Our Case Number: ACP-323066-25

Re: Gort Town Centre Public Realm Enhancement Project, Gort, Co. Galway
In the townlands of Gort, Co. Galway

Subject: **Gort Town Centre Public Realm Enhancement Project Planning Application**

This submission is made in relation to the Gort Town Centre Public Realm Enhancement Project Planning Application. I have reviewed the proposed plans, specifically the drawing 3160-BDP-00-XX-DR-L-0106 P05, and the drawing 3160-BDP-00-XX-SE-L-0007. As both a resident, restorer, property owner, artist, and the owner of businesses in the Barry's building on Bridge Street (National Inventory of Architectural Heritage reference number 30341038) I have a vested interest in the long-term success of this project. I would like to raise two distinct points for your consideration.

PROJECT TITLE	GORT TOWN CENTRE		
PROJECT NUMBER	P3003160		
DRAWN BY	LANDSCAPE GENERAL	SCALE	@ A1
CHECKED BY	ARRANGEMENT	DATE	1:200
DATE	SHEET 6 OF 9	REVISION	16.08.23
PROJECT NUMBER	3160-BDP-00-XX-DR-L-0106	REVISION	P05

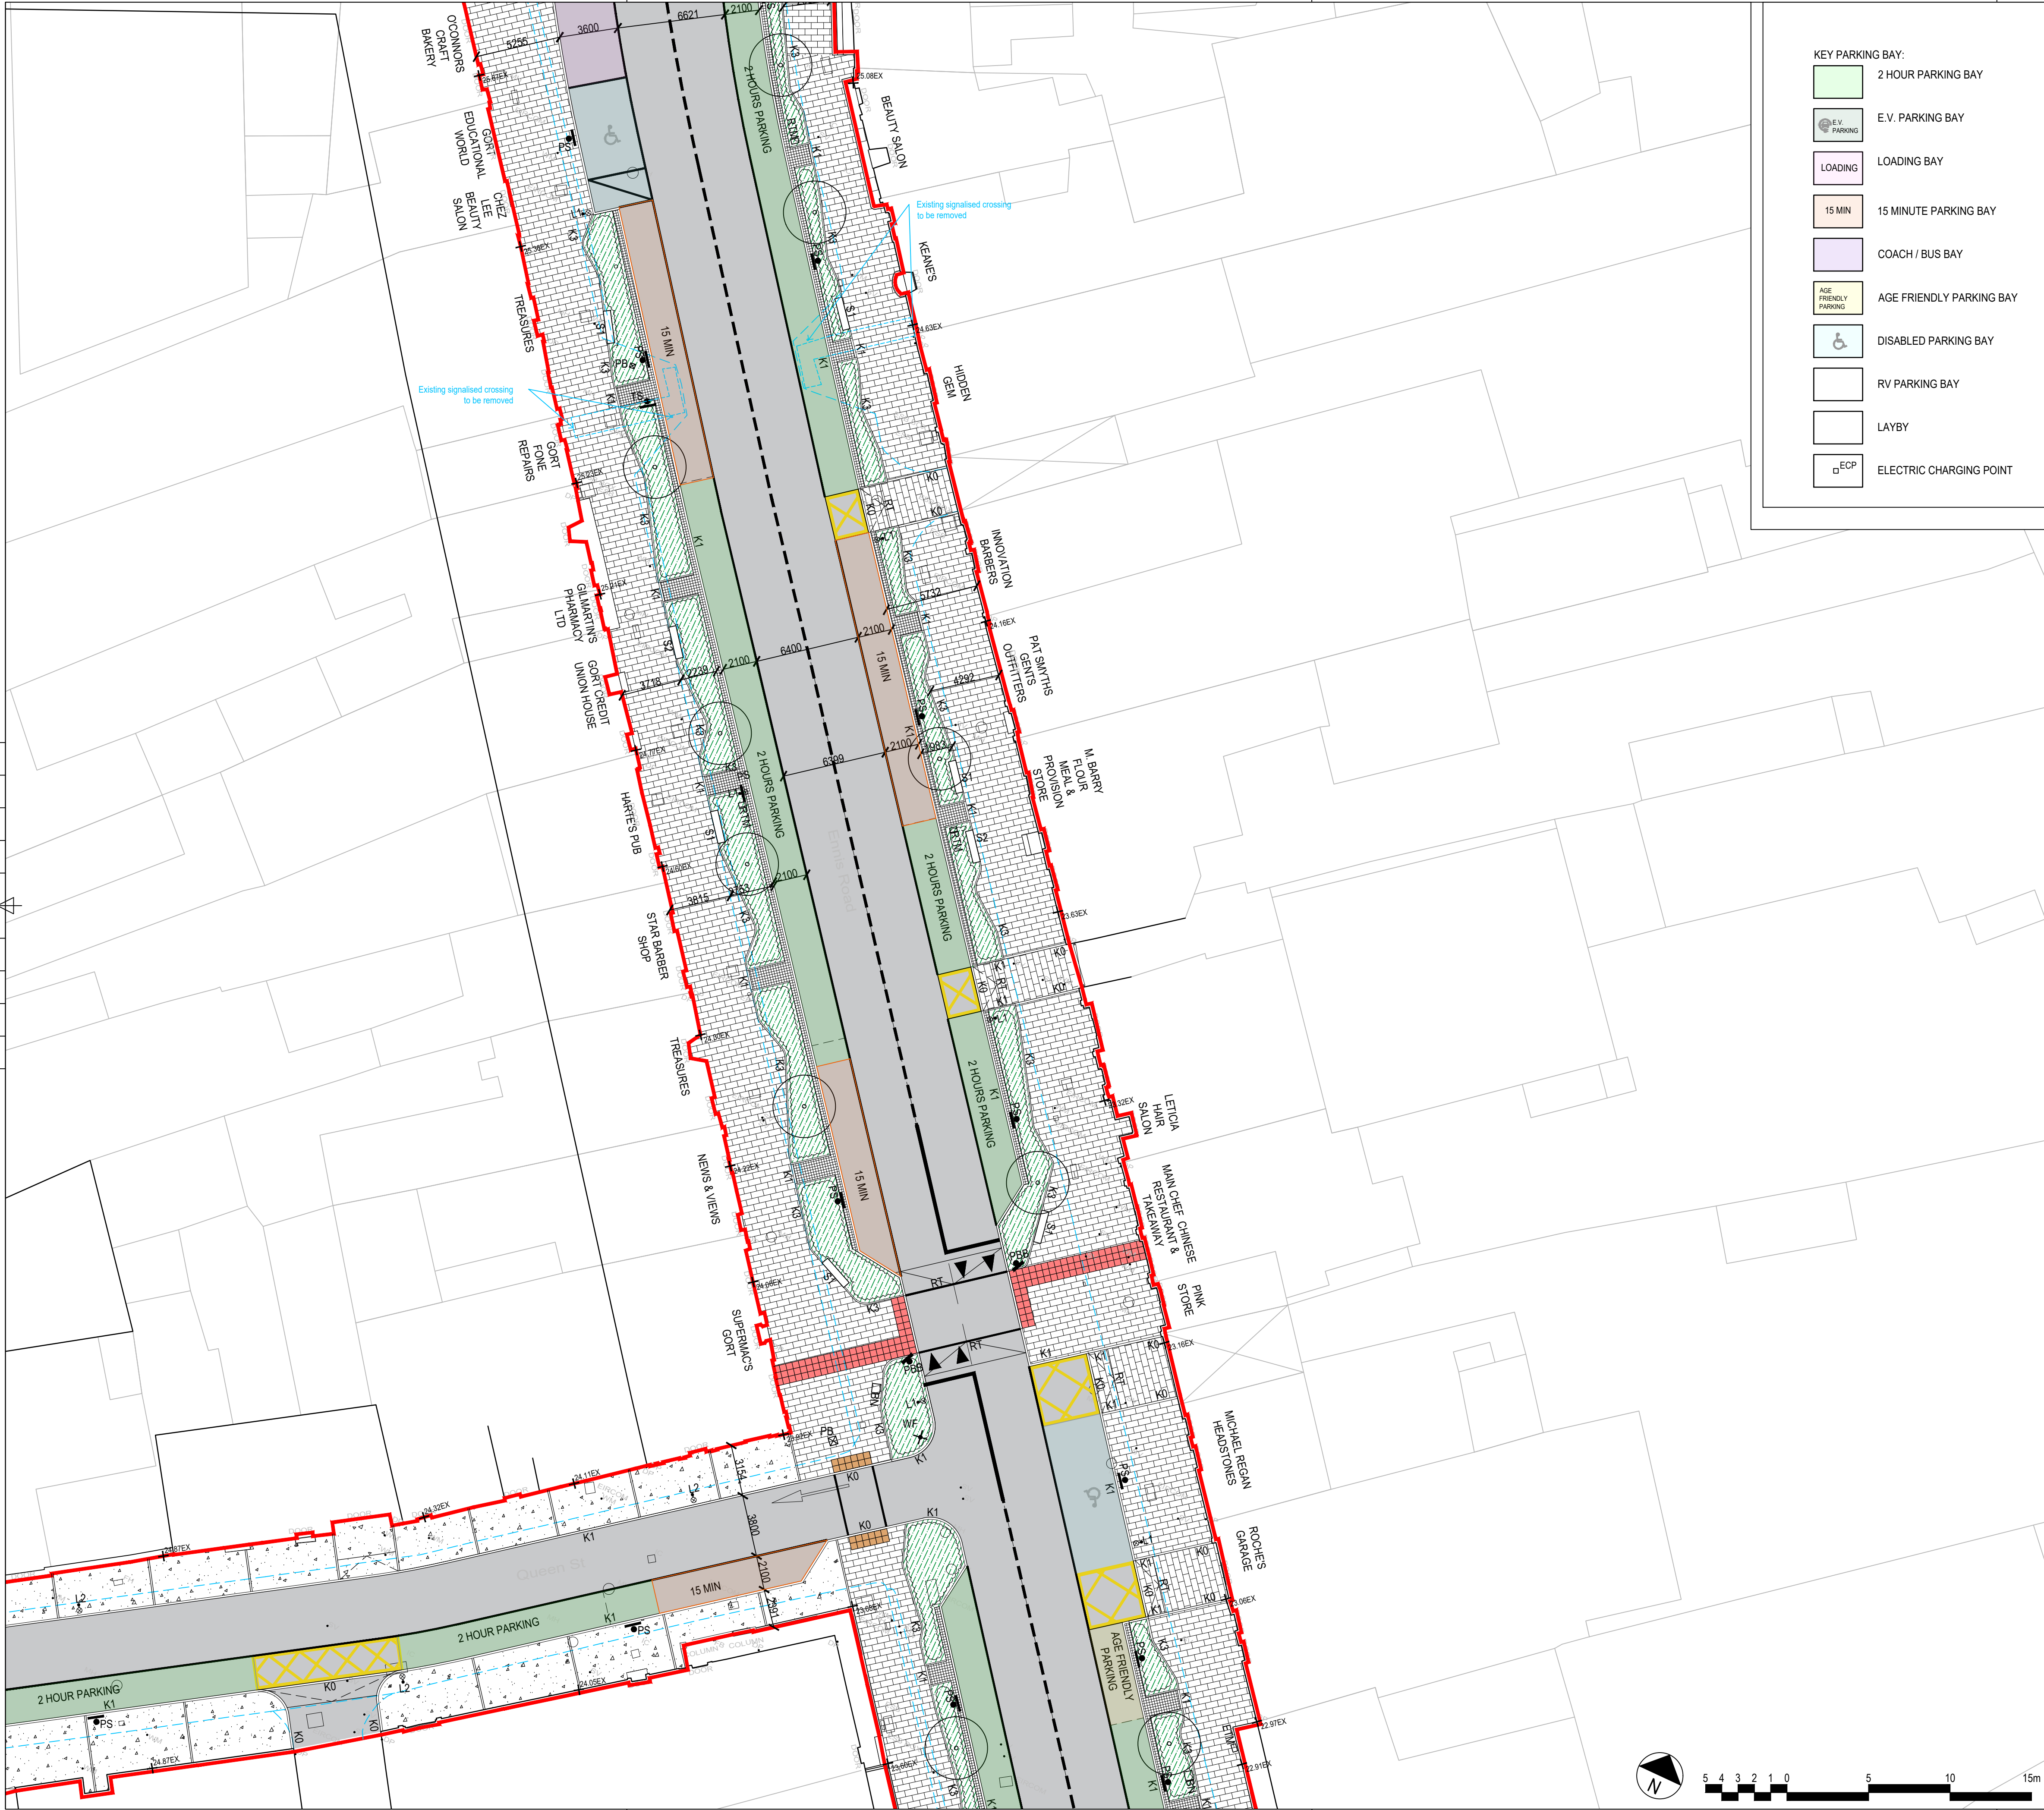
- **Removal of Benches:** We request that the proposed benches in front of our building be removed from the plan. For a coffee shop, our own tables and chairs are far more preferable and functional for our patrons and service provided. More importantly, we are concerned that benches would encourage loitering and become a late-night hang-out spot, particularly given the proximity of take-away restaurants. We already experience issues with loitering and litter on our front steps, and the placement of benches would only exacerbate this. As residents, with a young daughter, living upstairs, the potential for public drinking and anti-social behaviour is a serious concern for our family's safety and quality of life.

- **Relocation of Tree:** We have noted the proposed location for a new tree almost directly in front of our award winning coffee shop, Tal Vez Coffee. Based on our lived experience at this location, we must point out that in its planned position, the tree would block all precious afternoon sunlight. In Ireland, access to natural light is highly valued, and this placement would negatively impact both our business and the amenity of the public space. We request the tree be relocated to the other side of the building, where it would only cast a shadow on the corner and laneway, thus preserving afternoon sunlight for our shop and the streetscape.

- **Increased Paved Area:** We request an expansion of the paved area to create a larger, more functional space for outdoor seating for our coffee shop. This would allow us to place chairs and tables, increasing footfall and contributing to the social and economic vibrancy of the town.

- **Dedicated Space for Bicycles and a Sculpture:** Given the nature of our businesses, and with increased paved area, we propose the allocation of a dedicated space for bicycle parking and room for a small sculpture in front of our art gallery, The Cash Shop (www.thecashshop.ie). This would promote sustainable transport and reinforce Gort's cultural vibrancy.

- We request the inclusion of 15-minute parking bays to continue directly in front of our building. This would greatly benefit our businesses and neighbours by facilitating quicker collections and short shopping trips, encouraging local commerce and improving traffic flow.

PROJECT TITLE	
GORT TOWN CETRE	
P3001253	
DRAWING TITLE	SCALE @ A1
LANDSCAPE SECTION F EXISTING & PROPOSED	1:50
	DATE
	23.10.23
DRAWING NO.	REVISION
3160-BDP-00-XX-SE-L-0007	P01

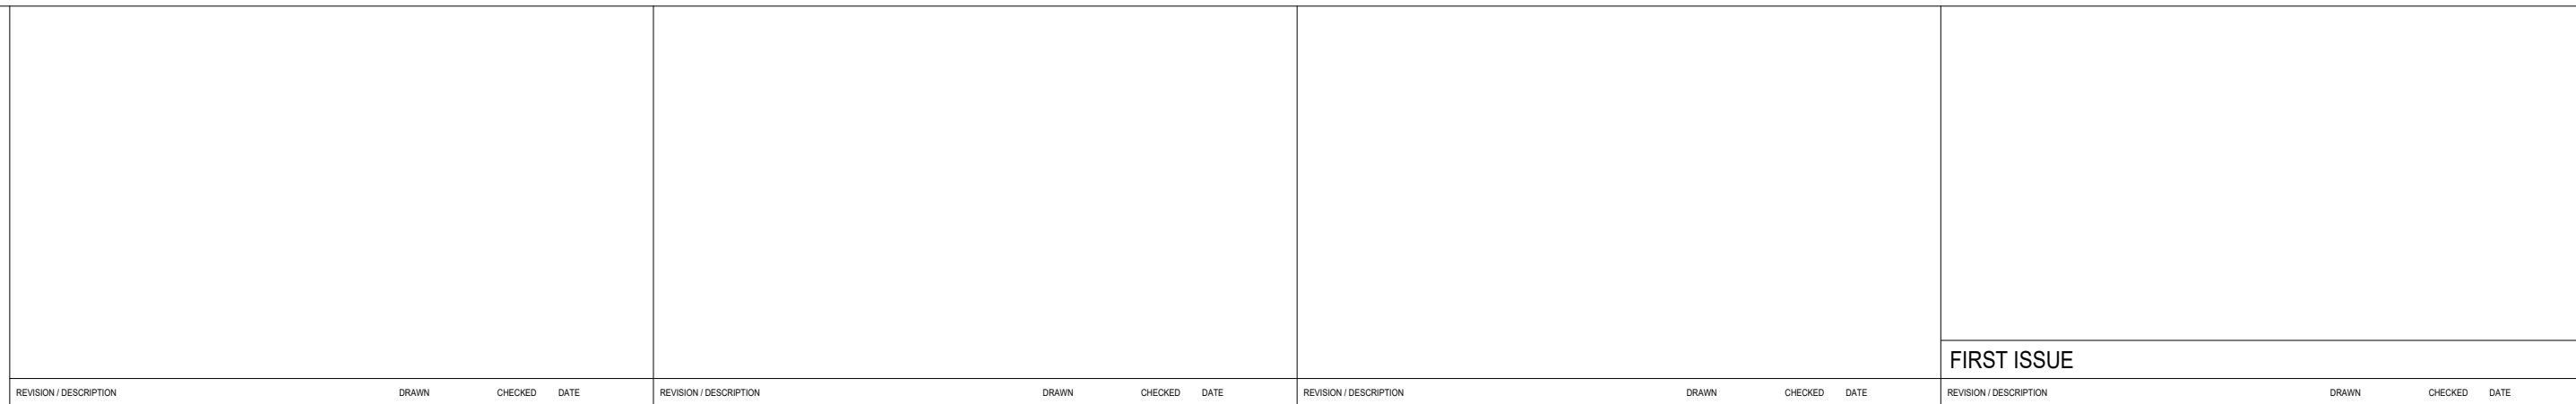
We wish to raise a formal objection to the proposal to lower the plinth of the Christ the King statue, as detailed in the plans, specifically the drawing, reference number 3160-BDP-00-XX-SE-L-0007. This specific aspect of the plan is not in line with proper planning and sustainable development, and we believe it poses unacceptable risks.

- **Heritage and Artistic Merit:** The monument is a protected structure with a Regional rating on the National Inventory of Architectural Heritage (reference number 30341016). The sculpture was created in 1932 by the renowned Irish artist Albert Power, and its base was designed by Thomas Cullen. It was commissioned by local woman, Ann Coen, in memory of the tragic loss of her son. Lowering the plinth would alter the original artistic and architectural vision and diminish the monument's significant heritage and artistic merit.

- **Risk of Irreversible Damage:** The process of lowering the plinth poses a substantial and unacceptable risk of damaging the protected statue. Such an action could lead to the irreversible harm of a valuable piece of public art. The potential for damage far outweighs any minimal benefit from this alteration.

- **Riskier access:** It would make the fragile marble sculpture much lower and possible to climb on and touch, thus greatly increasing the possibility of unintentional damage or vandalism.

- **Public and Sentimental Value:** This change is not only risky but is also likely to offend older citizens and the family that commissioned the statue. The statue and its original plinth are a part of the community's history and memory.

In conclusion, we request that the proposal to lower the plinth be reconsidered and that the original plinth be preserved to protect this important cultural asset.
